**KIRKLEES METROPOLITAN COUNCIL
INVESTMENT & REGENERATION SERVICE**

DELEGATED DECISION TO DETERMINE PLANNING APPLICATIONS

Reference No:	2026/62/90569/W
Site Address:	adj, 19-23, Market Street, Huddersfield, HD1 2EH
Description:	Installation of 1 BT Street Hub, incorporating 2 digital 75inch LCD advert screens, and associated BT Phone Kiosk removal (within a Conservation Area)
Recommending Officer:	John Holmes

DECISION - REFUSED

Drawing Title
EXISTING AND PROPOSED ELEVATIONS

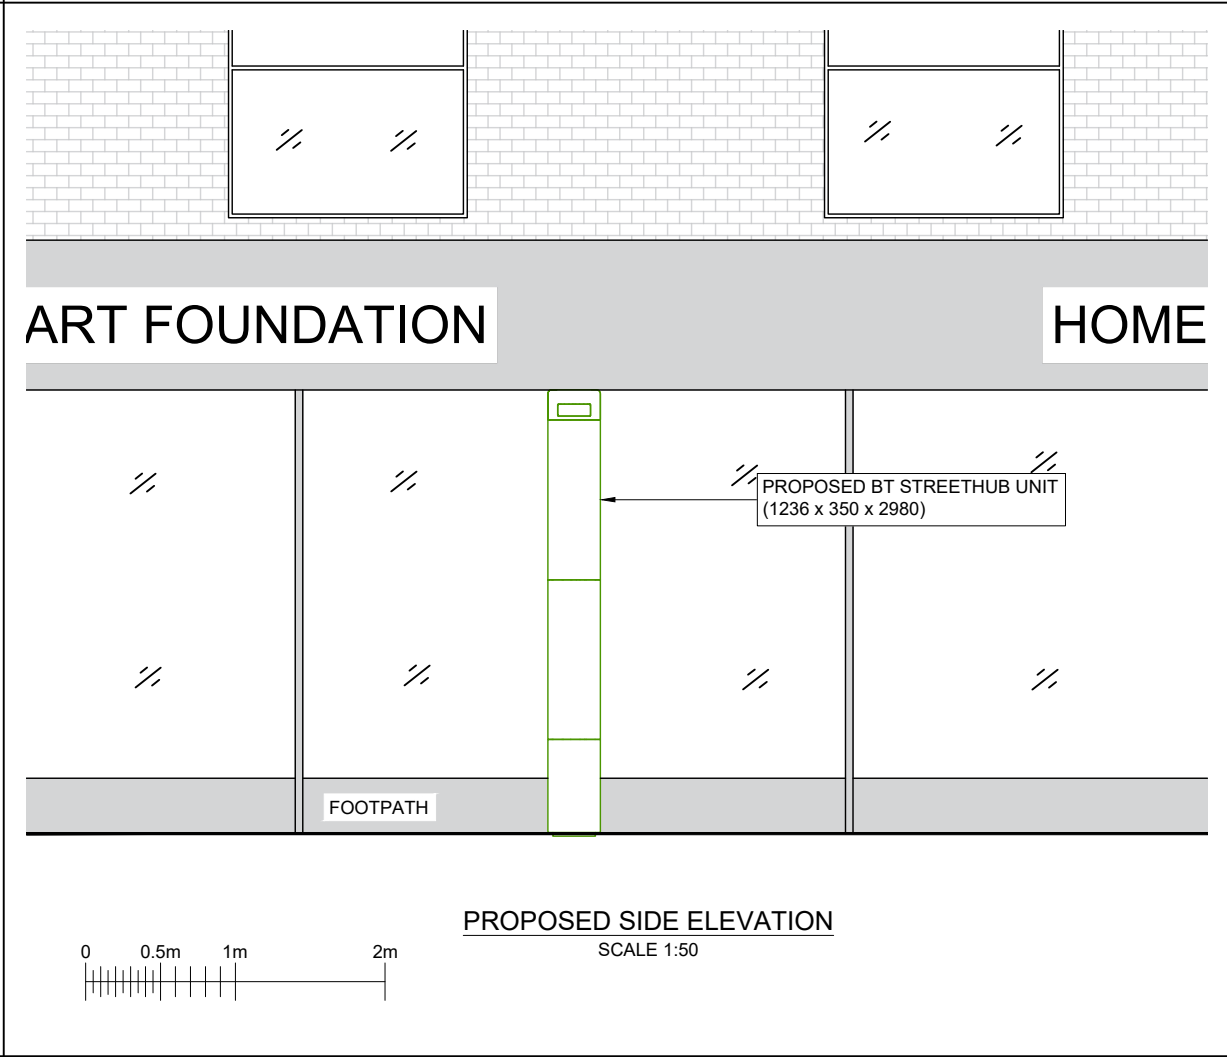
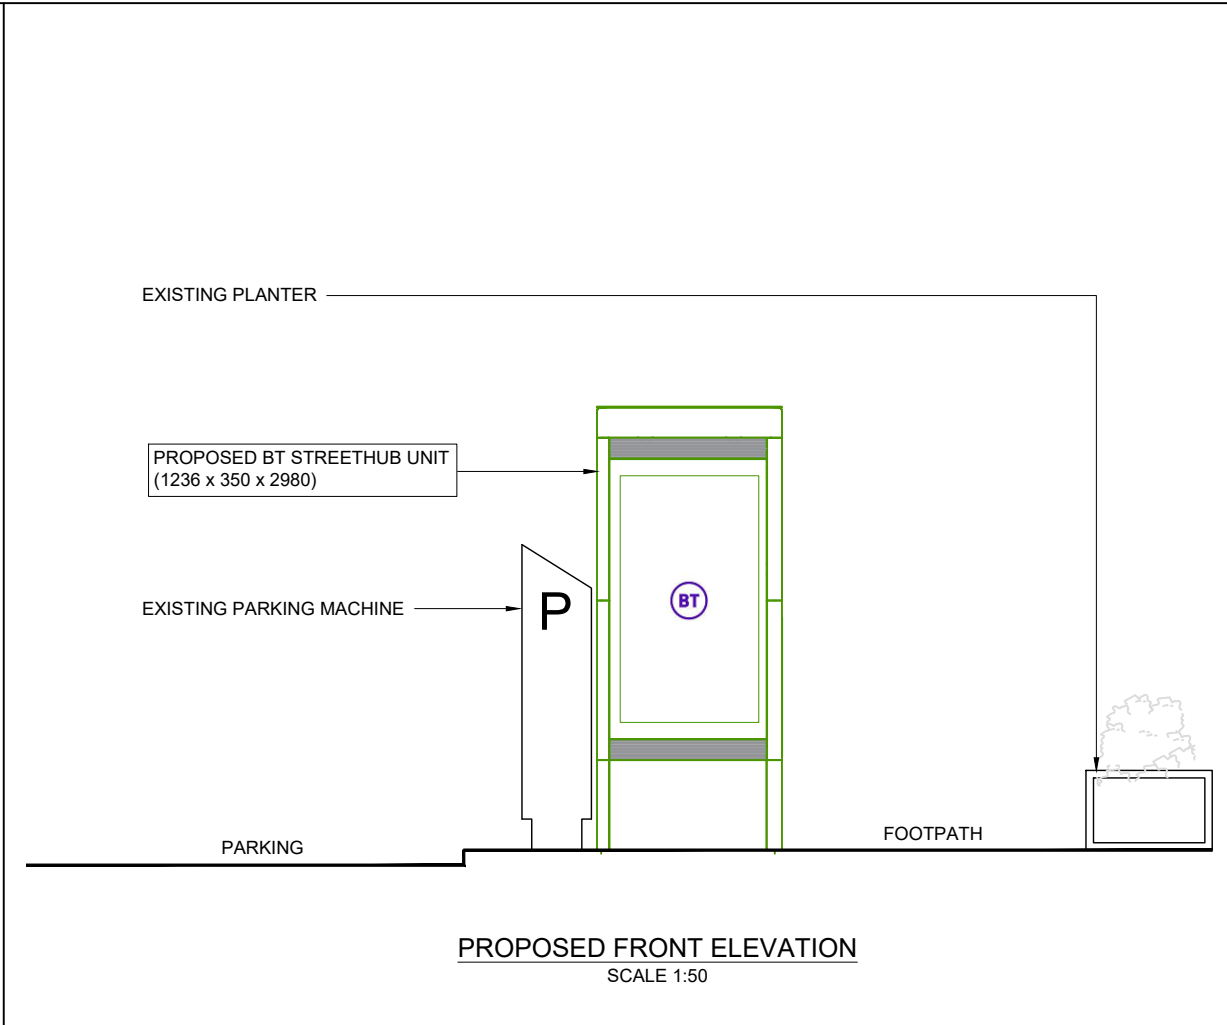
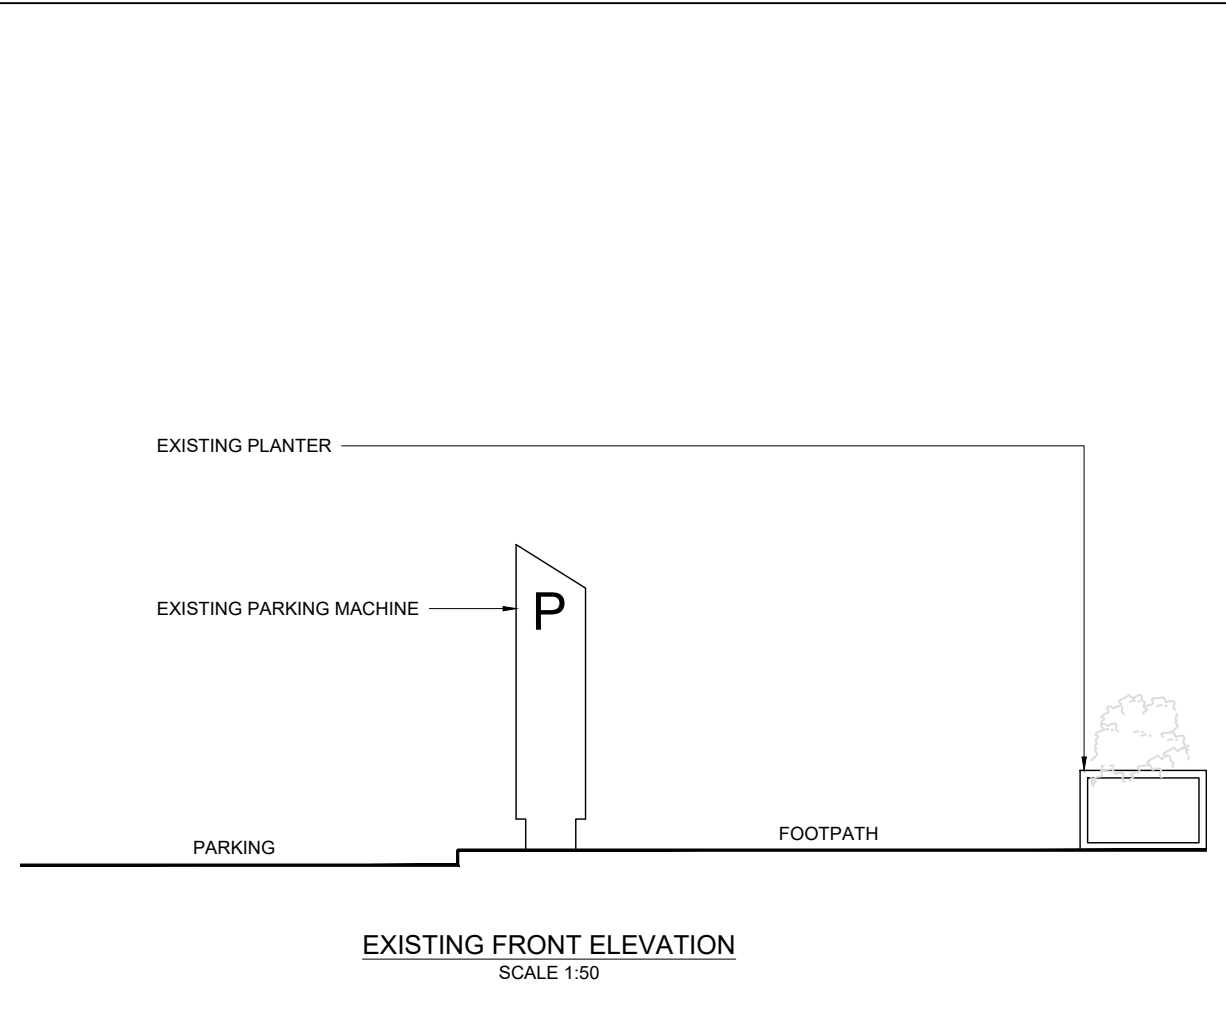
The proposal would be viewed in this context with a backdrop of historic buildings and their setting within the Wider Conservation Area. There is currently a number of structures and other street furniture in this part of the street, the proposal would see the usable width of the pavement narrowed at this point. The proposal would result in a structure of increased size and prominence which would be further exacerbated by the intention to illuminate signage upon the structure. The nature of the street is such that it would be highly prominent from a number of locations to the north and south. The presence of an existing free standing illuminated sign located in the street, to the north and on the other side of Market Street would lead to an increased impact in terms of this part of the street becoming cluttered and dominated by illuminated signage. Signage upon the bus stop on the opposite side of the street would mean the proposal would add a further signage scheme in close proximity to two existing signs.

The introduction of a further 3m high structure featuring a pair of display panels would add further illuminated street clutter which would, especially in

the context of already existing digital display screens, detract from the character of the area and cause cumulative harm to the conservation Area and also the setting of nearby listed buildings. It would thereby conflict with both Huddersfield Blueprint initiatives mentioned above and the aims of Policies LP17(a), LP24(a) and LP35, and also those of Chapter 16 of the NPPF, and the Council's duty under sections 66 and 72 of the Planning (Listed Buildings and Conservation Areas) Act 1990,

In some locations, BT Street Hubs may give rise to increased interference with pedestrian flow and vehicle-pedestrian intervisibility, in this case the width of the footpath would be reduced and visibility / a distraction created in proximity to a signalised junction. The ability to access vehicles from the parking area which the proposal would be adjacent to would be impeded to some extent.

It is inevitable that the introduction of internally illuminated LED advertisement screen displays with changing of static images would draw the attention of road users and pedestrians to a significantly greater degree than the open and unimpeded view over this part of the highway. These would draw the eye of road users at moments which require care and attention to safely negotiate this part of the highway which, whilst signalised, may cause confusion or distraction for drivers in relation to changing of the lights.

1. The proposed Street Hub would include illuminated screens on both sides. These are an integral part of the development under consideration. The proposed Street Hub and digital display screens, owing to their scale, prominent siting, and means of illumination, would be a visually incongruous and intrusive feature that would cause harm to the significance of the Huddersfield Town Centre Conservation Area, and listed building close by. The public benefits associated with the proposed development would not outweigh the less than substantial harm caused to the significance of the Conservation Area and listed building. In addition, the proposal would add further illuminated street clutter which would detract from the character of the wider Town Centre, and would prejudice the aims of the Huddersfield Blueprint, a ten-year regeneration initiative to rejuvenate the Town Centre and enhance public spaces. The proposal is therefore contrary to Policies LP17(a), LP24(a), and LP35 of the Kirklees Local Plan, Chapters 12 and 16 of the NPPF and Sections 66 & 72 of the Planning (Listed Buildings and Conservation Areas) Act 1990.

1. The proposed Street Hub would include illuminated screens on both sides. These are an integral part of the development under consideration. The proposed illuminated screens, by virtue of their siting, illumination and the orientation of advertisements displayed, and by reason of conflicting with the clarity and effectiveness of a signalised junction, upon a busy section of Market Street which experiences high flows of pedestrians would create an unnecessary distraction to road users and pedestrians along a well-used vehicular and pedestrian route in Huddersfield town centre. This would be to the detriment of public and highway safety and the local highway network adjacent to the site, and thus contrary to Policy LP21 of the Kirklees Local Plan.
